About the application

Application number: 2020/92331	
What is the application for?:	Outline planning application for demolition of existing dwellings and developmen
Address of the site or building:	Land east of, Leeds Road, Chidswell, Shaw Cross, Dewsbury
Postcode:

User comments

Blue infrastructure Legend

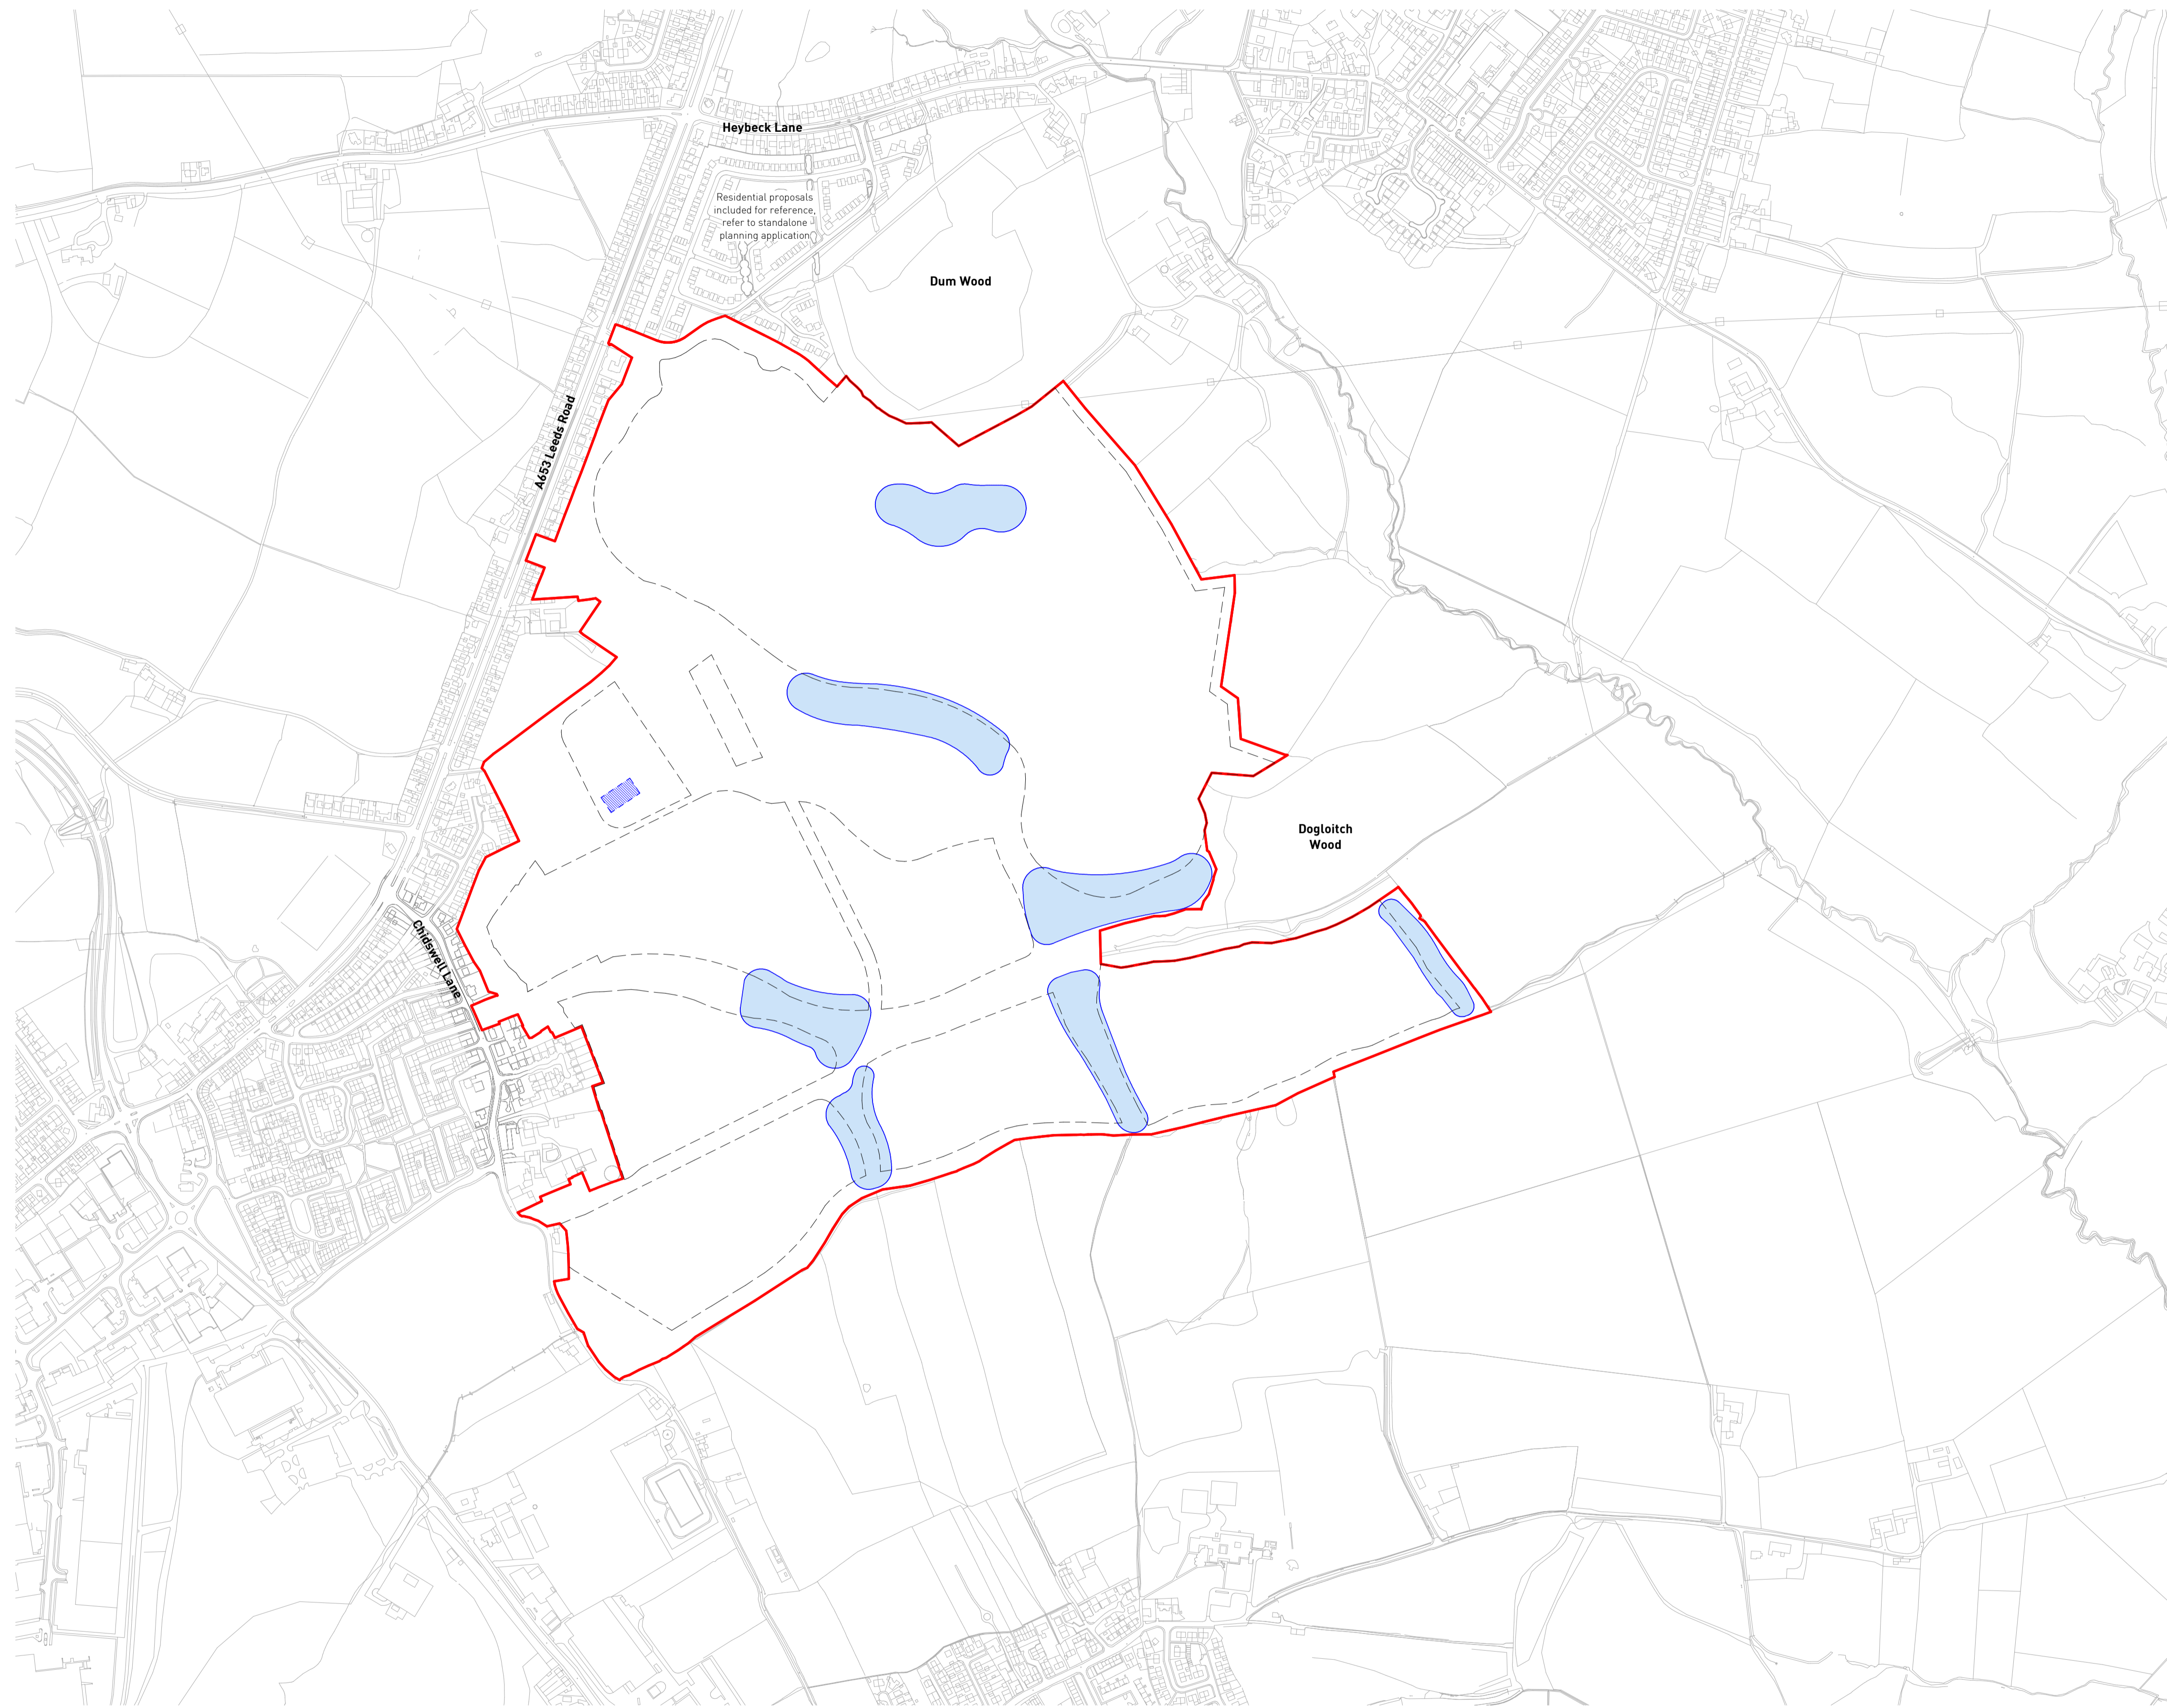
Type of comment: A general comment
Considering large number of dwelling and large area of industrial use intended and landscape of site, adequate provision for handling of water from large run off areas of roads and driveways and yards in commercial areas should be provided to prevent flooding of low lying land on site.
